## Field Report

**Dated 7-8-2016**

**Project:** Park Danforth New Residence Wing  
**Project #:** 3422  
**Date/Time:** Friday July 8, 2016 9am  
**Participants** Paul Becker (BSE), Ken Theriault (PC)

CONTENT:  
 LEVEL 1-AUDITORIUM & CONNECTOR FOUNDATION PLAN

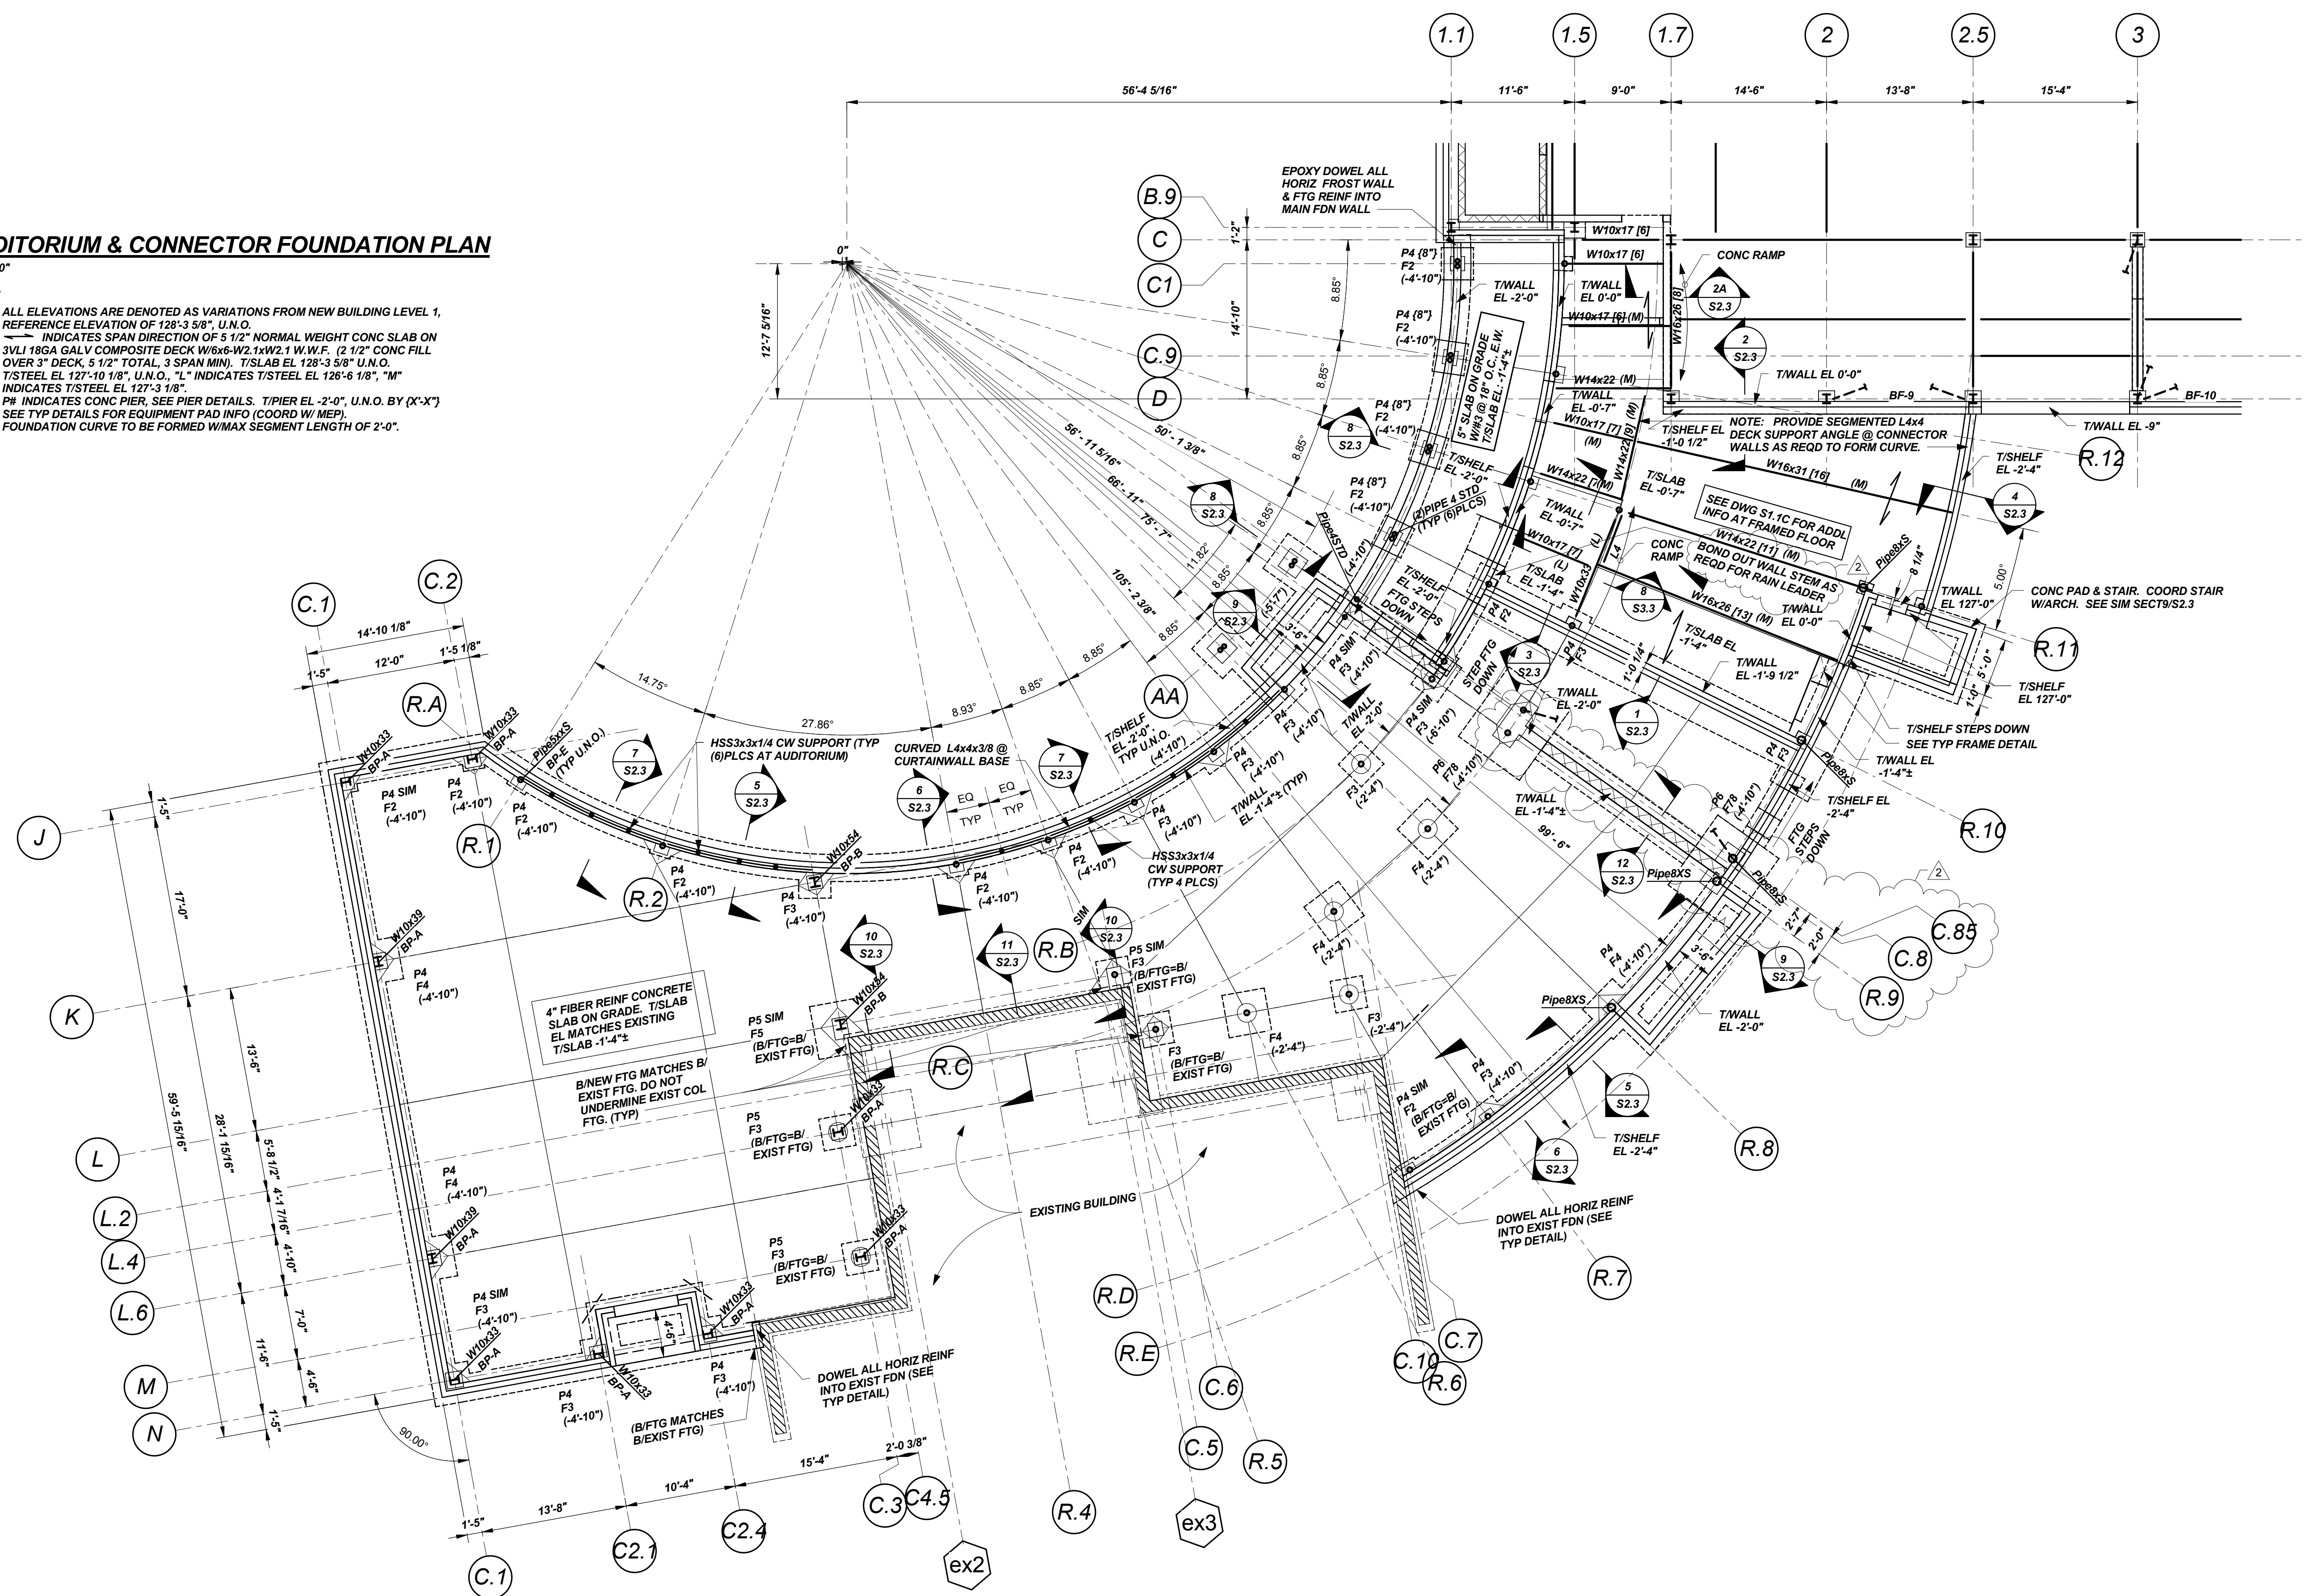
Visited the site to review the existing structure in the vicinity of the A5 Line by the exterior “knuckle” in the building. Earlier in the week the fifth floor balcony column at A5 Line became free during erection and fell to the ground, striking the foundation at the prominent building corner at the intersection of A and E lines. The top of the foundation wall was spalled due to the impact.

I did not observe any damage to elevated structural components of the building. The only observed damage was to the top of the foundation wall. Columns being erected at A1 line during my visit were using the erection clips.

I recommended to Ken that column-to-column field welds be completed to the greatest extent possible to ensure column stability prior to removal of the erection clips. He relayed this info to Davis Erectors.

Please refer to below sketch for repair recommendations.
